<b>Application Ref:</b>	3/2025/0951			 Ribble Valley Borough Council <small>www.ribbonvalley.gov.uk</small>
<b>Date Inspected:</b>	25/3/26	<b>Site Notice:</b>	25/3/26	
<b>Officer:</b>	BT			
<b>DELEGATED ITEM FILE REPORT:</b>				<b>APPROVAL</b>

<b>Development Description:</b>	Reserved matters application relating to access, appearance, landscaping, layout and scale for the erection of an agricultural worker's dwelling following outline planning permission 3/2021/0674.
<b>Site Address/Location:</b>	Lower Edge Farm, Tinklers Lane, Slaidburn, BB7 4TP.

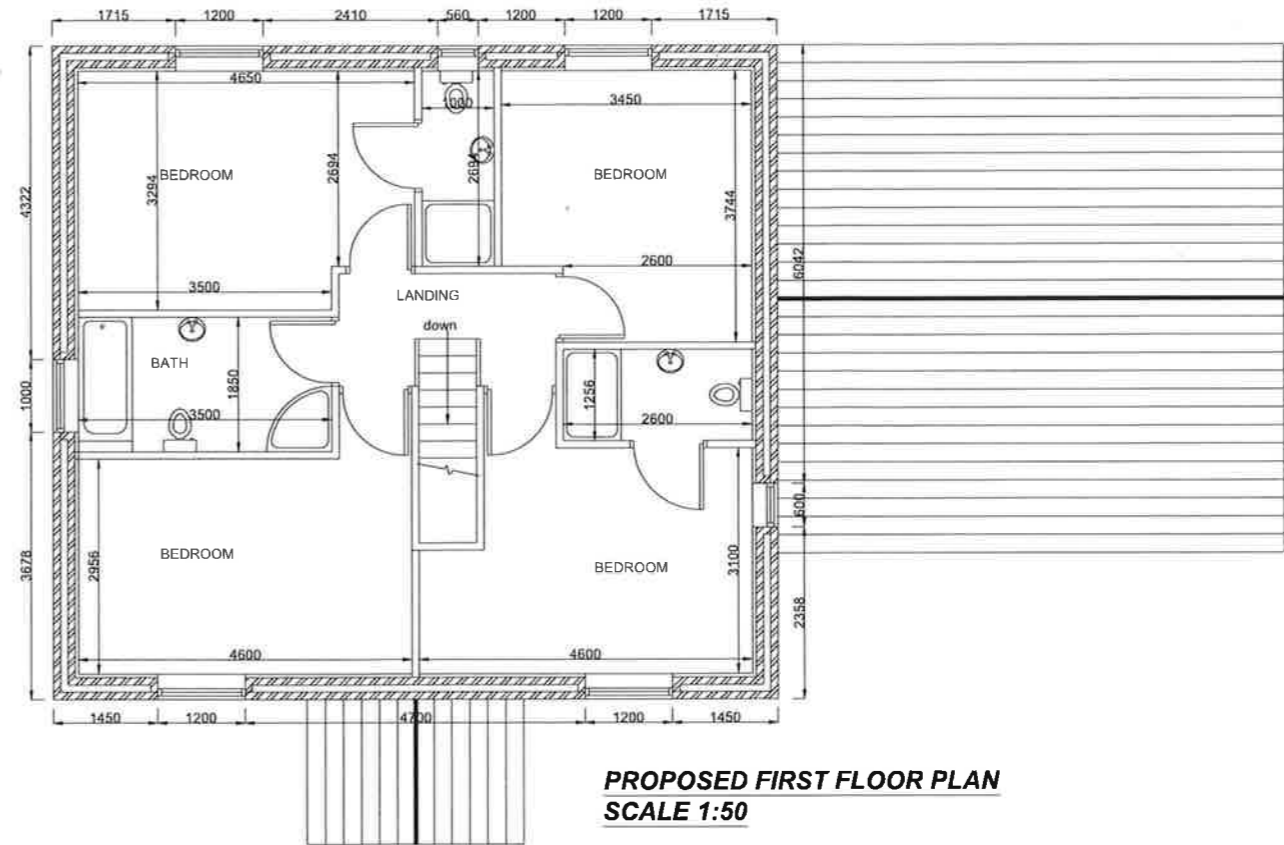
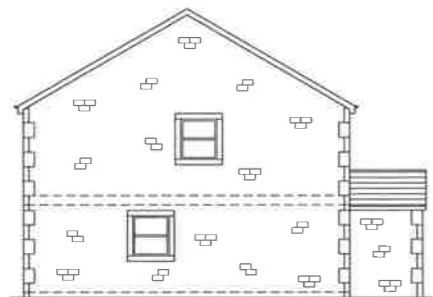
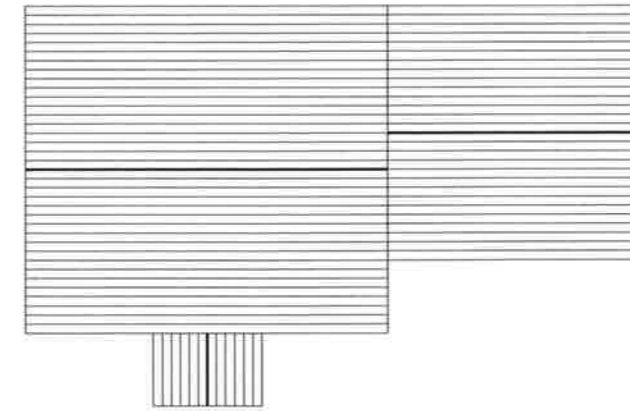
Furthermore, following negotiation some minor revisions to the design of the proposed dwelling have been secured which include the use of timber window frames and doors (instead of the previously proposed PVC design) along with a revised scheme of fenestration whereby the proportions of the dwelling's front and rear first floor window openings have been reduced so as to appear subservient to the dwelling's larger ground floor window openings. In addition, the proposed dwelling would be detailed in stone and slate which would be wholly in keeping with the rural vernacular of dwellings within the locality. As such, the proposed dwelling would read as a congruent addition to the site in the context of the site's rural setting.

Proposed Site Plan
Scale (1:500)

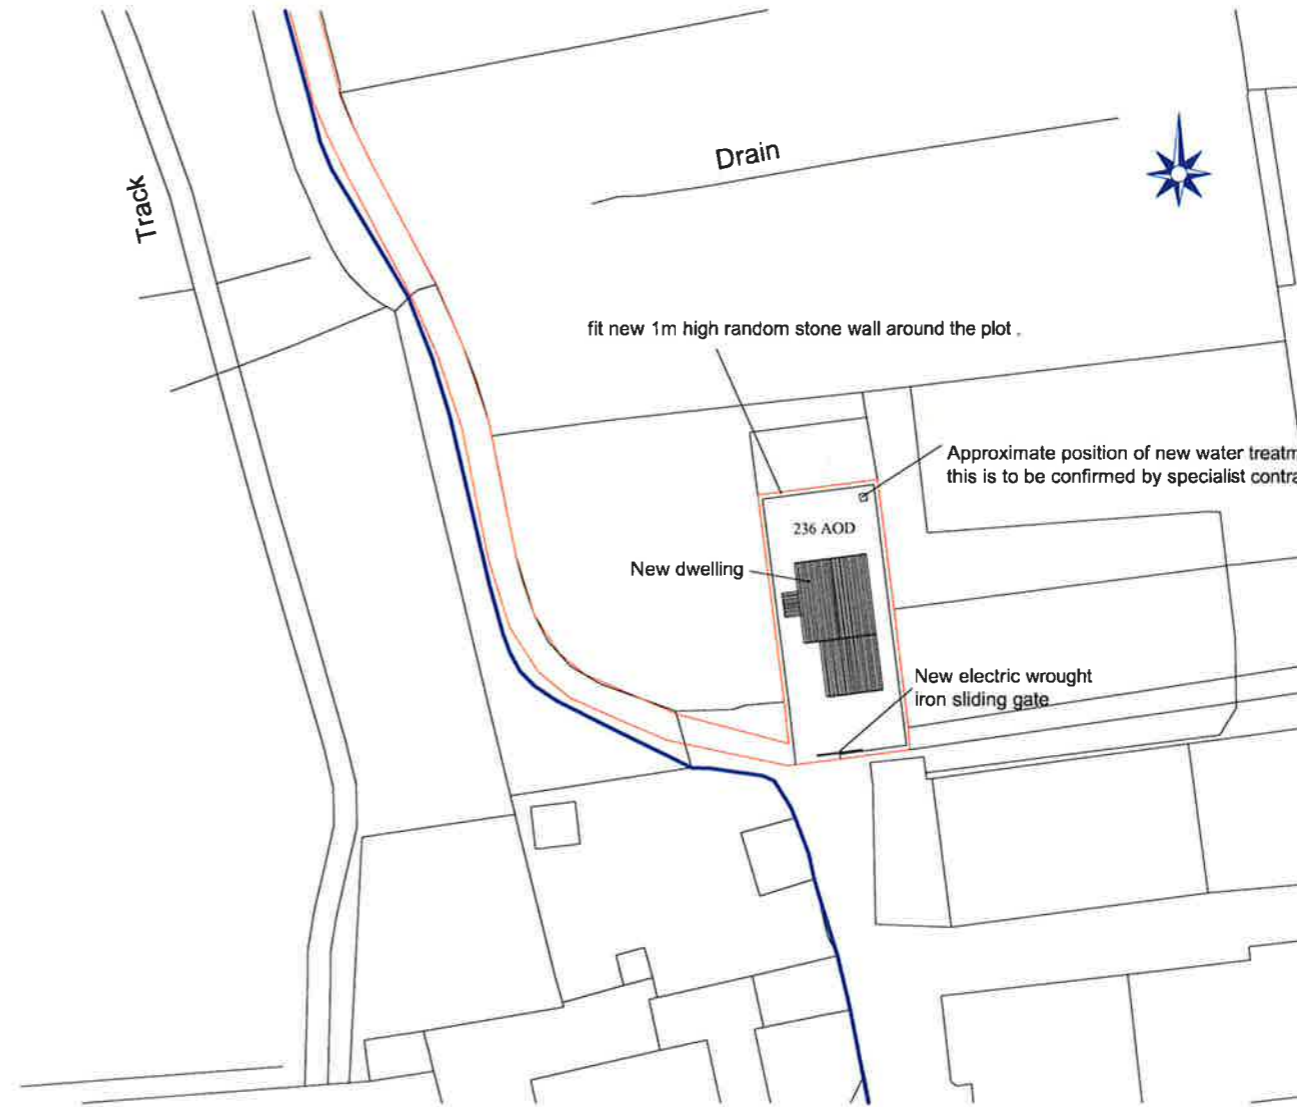
Indicative details of hard and soft landscaping have been provided on the submitted proposed site plan which proposed the introduction of a 1 metre high random stone boundary wall to enclose the dwelling's domestic curtilage area along with hardstanding and a lawned area, all of which are considered to be acceptable, subject to further details being provided with regards to the proposed use of materials. The original application submission included the proposed installation of an ornately designed electric wrought iron sliding gate however this feature was considered to be at odds with the rural character of the site and as such has since been replaced with electric swinging timber gates which are considered to be more appropriate for the character of the site, subject to further details being provided with regards to their materiality and appearance.
